From: Thomas Callaway
Sent: 30 April 2015 15:27
To: Planning.Responses
Subject: RE: Planning Consultation on: LU/98/15/PL

APPLICATION NO: LU/98/15/PL

Site Address: 25 Peregrine Road Littlehampton BN17 6DT

Description of Works: Proposed dwelling

Drawing: **PLANS**

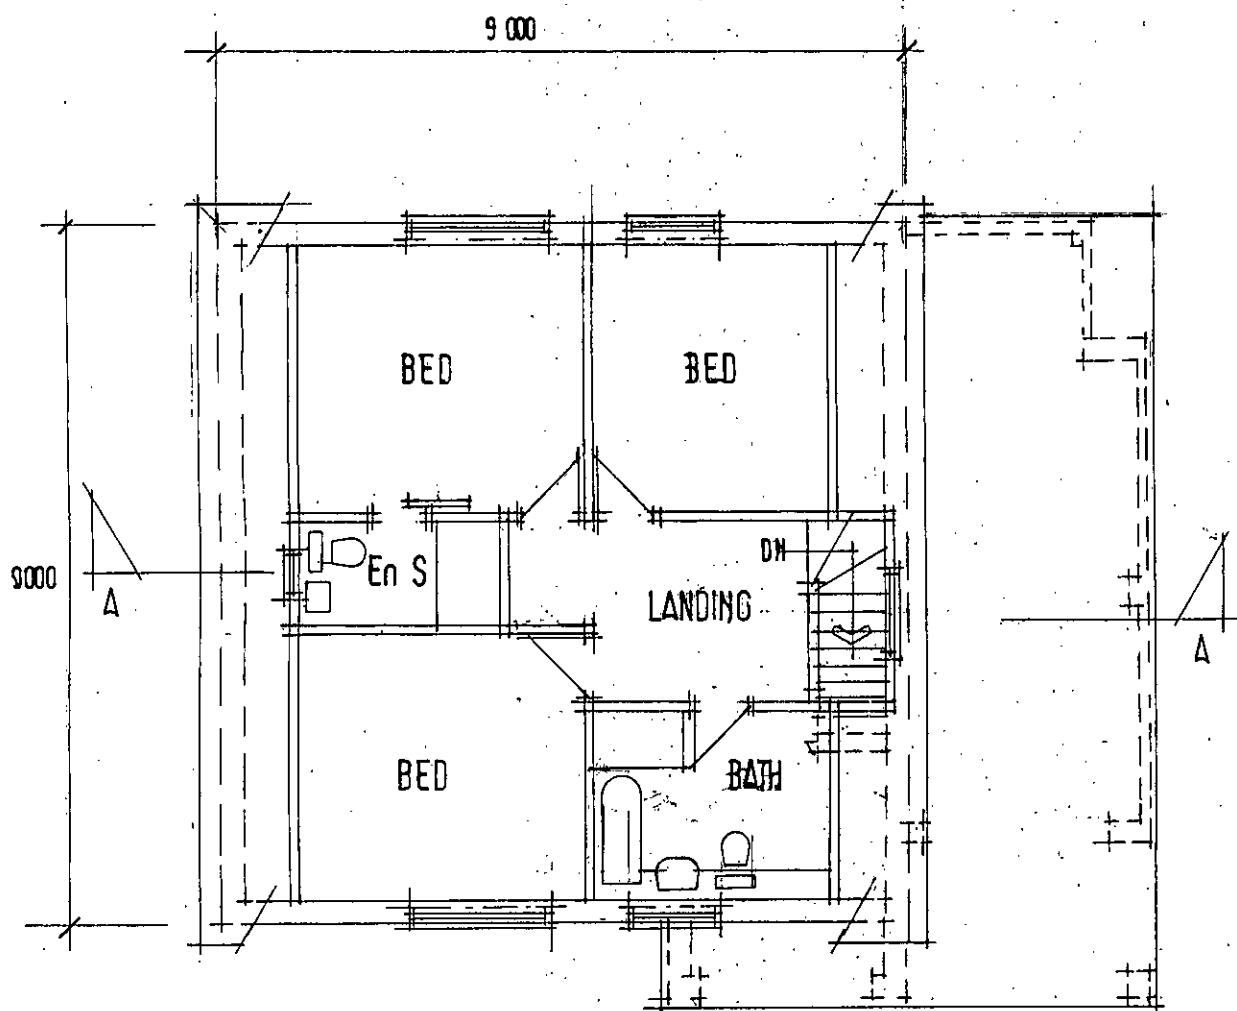
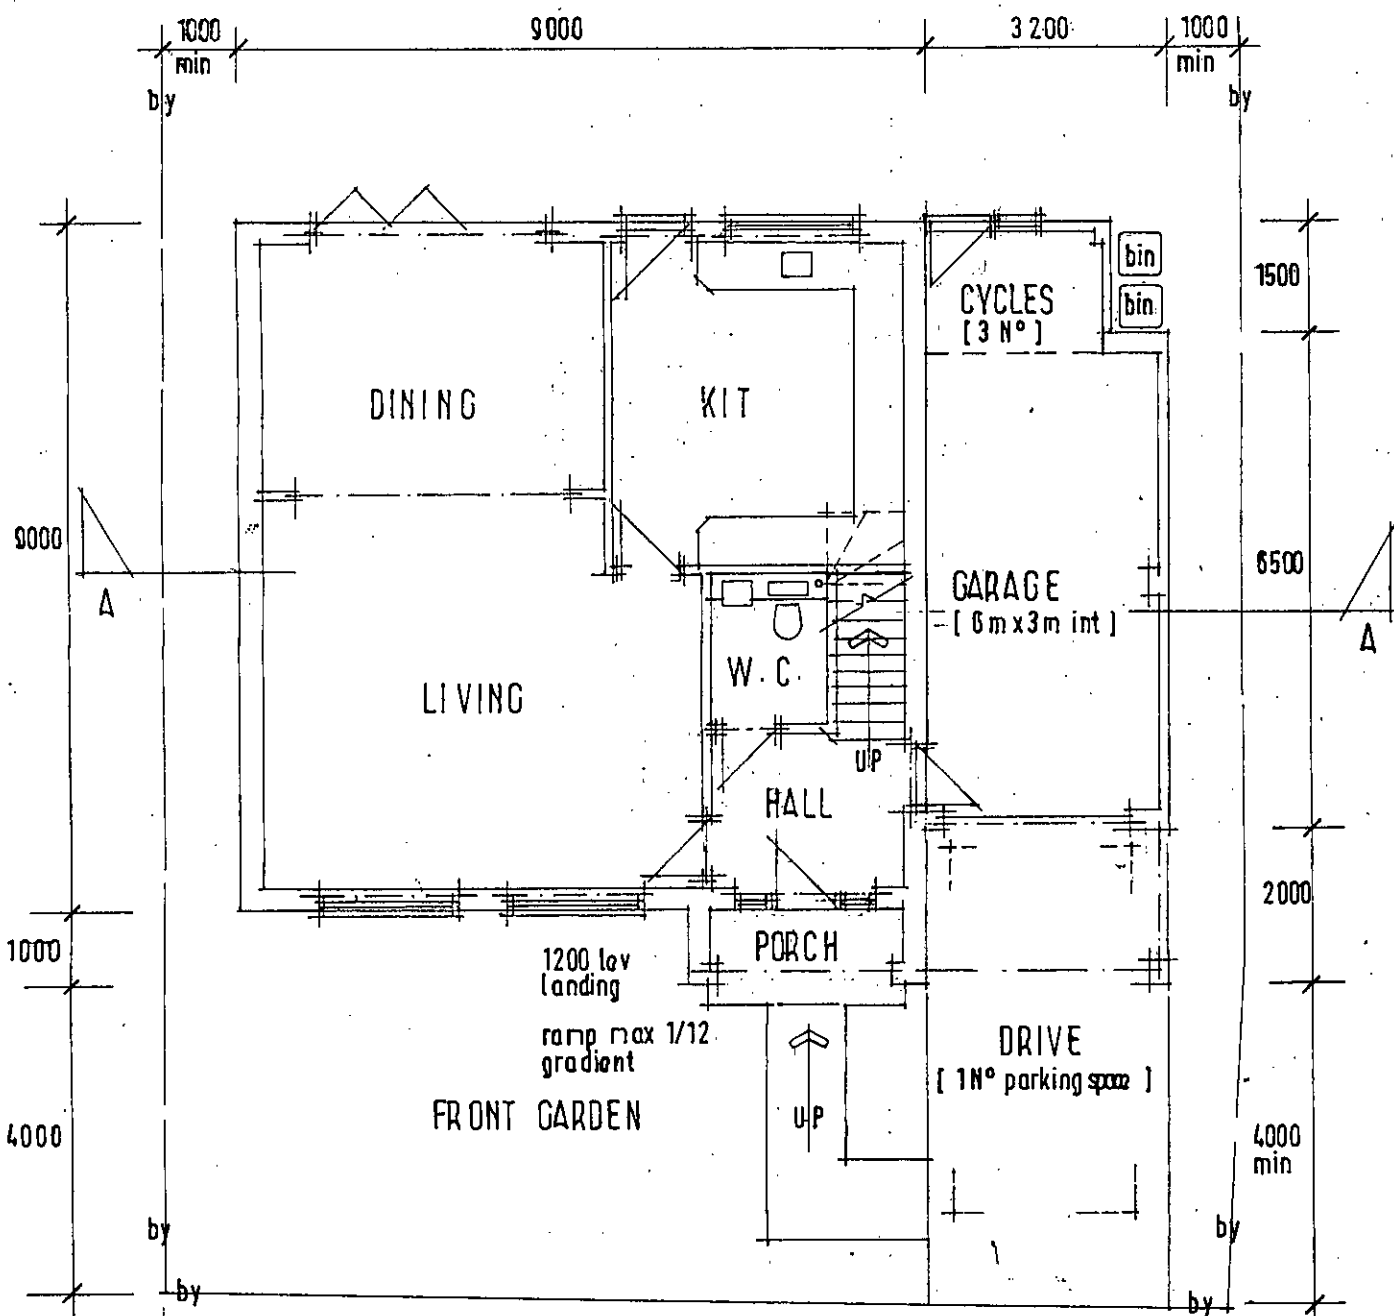
The access for the proposal crosses a public sewer, Southern Water may need to be consulted.

The applicant states that surface water will be discharged to soakaway.

Infiltration rates for soakage structures are to be based on percolation tests undertaken in the winter period and at the location and depth of the proposed structures. The percolation tests must be carried out in accordance with BRE 365, CIRIA R156 or a similar approved method and cater for the 1 in 10 year storm between the invert of the entry pipe to the soakaway, and the base of the structure. It must also have provision to ensure that there is capacity in the system to contain below ground level the 1 in 100 year event plus 30% on stored volumes, as an allowance for climate change. Adequate freeboard must be provided between the base of the soakaway structure and the highest recorded annual groundwater level identified in that location.

Any SuDS or soakaway design must include adequate groundwater monitoring data to determine the highest winter groundwater table in support of the design. The applicant is advised to discuss the extent of groundwater monitoring with the Council's Engineers. Supplementary guidance notes are also enclosed for information.
